**KIRKLEES METROPOLITAN COUNCIL
INVESTMENT & REGENERATION SERVICE**

DELEGATED DECISION TO DETERMINE PLANNING APPLICATIONS

Reference No:	2024/62/92374/E
Site Address:	13, Crescent Walk, Ravensthorpe, Dewsbury, WF13 3BG
Description:	Erection of part two storey and part single storey rear extension, two storey side extension, front extension, and loft conversion with dormer to front elevation
Recommending Officer:	Jennifer Booth

DECISION - REFUSED

PROPOSED REAR ELEVATION
(NORTH WEST)

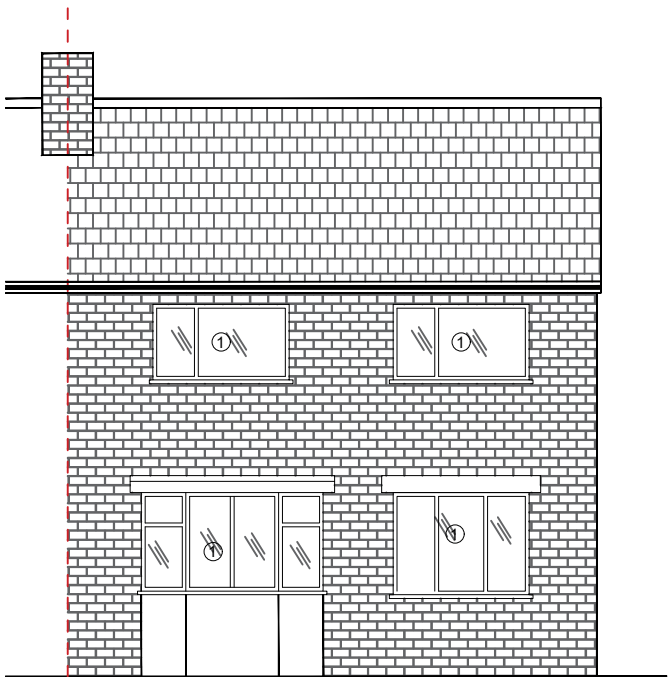
The previous application failed in part due to the due to the roof form. Whilst the current proposal has improved the roof design to a degree and is now similar to the roofs over the rear extensions of the adjacent neighbouring properties, the footprint of the rear extension would be restrict the remaining space around the building. Where adjoining buildings have been extended they retain adequate space the neighbouring boundaries thereby avoiding an overly cramped form of development. The width proposed along with height and design results in a development that lacks subservience. Despite the use of brick for the walling with tiles for the roof covering which would match the main house, the rear extension is considered to be unacceptable in terms of visual amenity.

The property has a very limited rear amenity space with a depth of less than 6.6m. As such, the proposed rear extension would be less than 4m from the boundary with the neighbouring 53 The Crescent and whilst the angling of the rear elevation of the neighbouring property prevents any significant impact, the proposed rear extension would result in an unacceptable overlooking of the neighbour's amenity space. The proximity of a two storey extension so close to the boundary would also form an imposing and overbearing impact on the neighbour's amenity space.

The proposed rear extension, by reason of the extreme proximity to the rear boundary would result in unacceptable overlooking together with an imposing and overbearing impact on the amenity space of the neighbouring 53 The Crescent. To permit the proposals would be contrary to Policy LP24 of the Kirklees Local Plan, KDP3 & KDP6 of the House Extensions & Alterations SPD and Chapter 12 of the National Planning Policy Framework.

The proposed rear extension, would result in very limited space to the rear boundary and as such would result in a cramped appearance which would be out of character with the area. To permit the proposals would be contrary to Policy LP24 of the Kirklees Local Plan, KDP1 & KDP2 of the House Extensions & Alterations SPD and Chapter 12 of the National Planning Policy Framework.

1. The proposed rear extension, by reason of the scale and design along with proximity to the rear boundary would result in unacceptable overlooking together with an imposing and overbearing impact on the amenity space of the neighbouring 53 The Crescent. To permit the proposals would be contrary to Policy LP24 of the Kirklees Local Plan, KDP3 & KDP6 of the House Extensions & Alterations SPD and Chapter 12 of the National Planning Policy Framework.

2. The proposed rear extension, due to the scale and design would not appear subservient to the host, reducing the space to the rear boundary and appearing cramped which would be out of character with the area. To permit the proposals would be contrary to Policy LP24 of the Kirklees Local Plan, KDP1 & KDP2 of the House Extensions & Alterations SPD and Chapter 12 of the National Planning Policy Framework.
